**ROUSE HILL RESIDENTS ACTION GROUP
INCORPORATED (INC 1700899)**

13th November 2019

**SSD-9472 Sikh Grammar School
Lots 42 & 43 DP30186 151-161 Tallawong Road Rouse Hill**

**Figure 1 Maximum Building Height of the Subject Site and Surrounding Area (Source: NSW Legislation, 2019)**

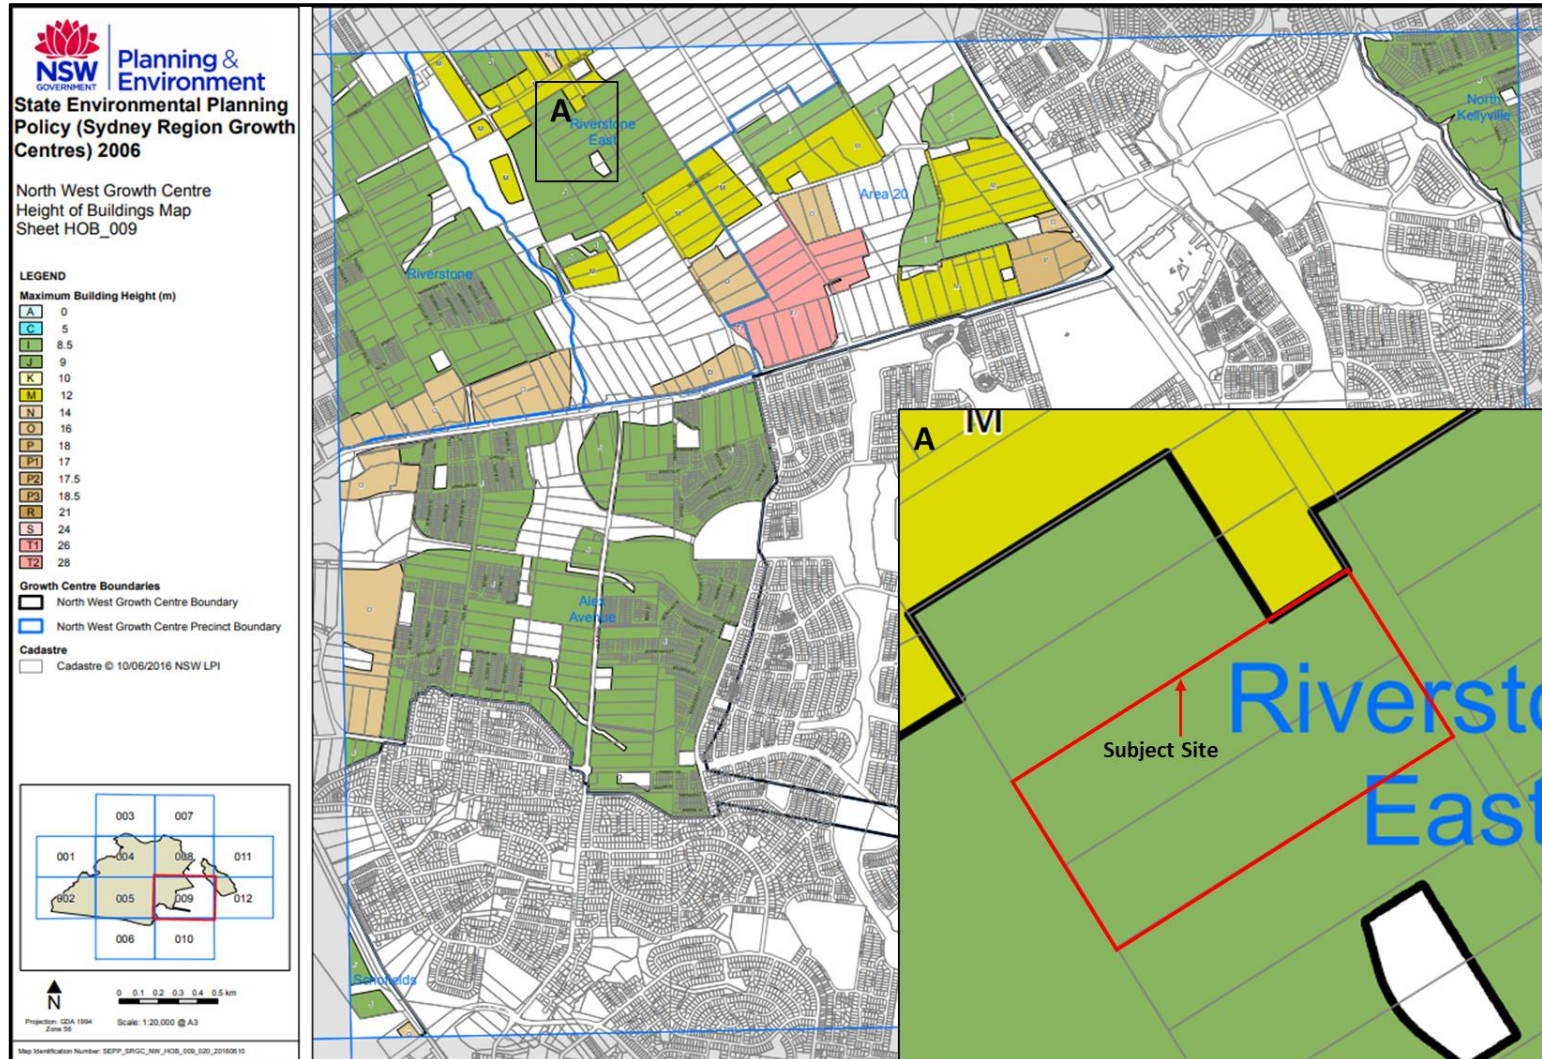
The site is zoned R2 Low Density Residential. The height limit for the site is 9m which is intended to result in development of the site presenting a reduction in scale from the 12m height limit in the planned local centre on Guntawong Road.

The proposal seeks a maximum building height of more than double the existing height limit at 18.19m. The justification for this significant breach relies on the commercial viability, operational requirements of the school and demand for infrastructure.
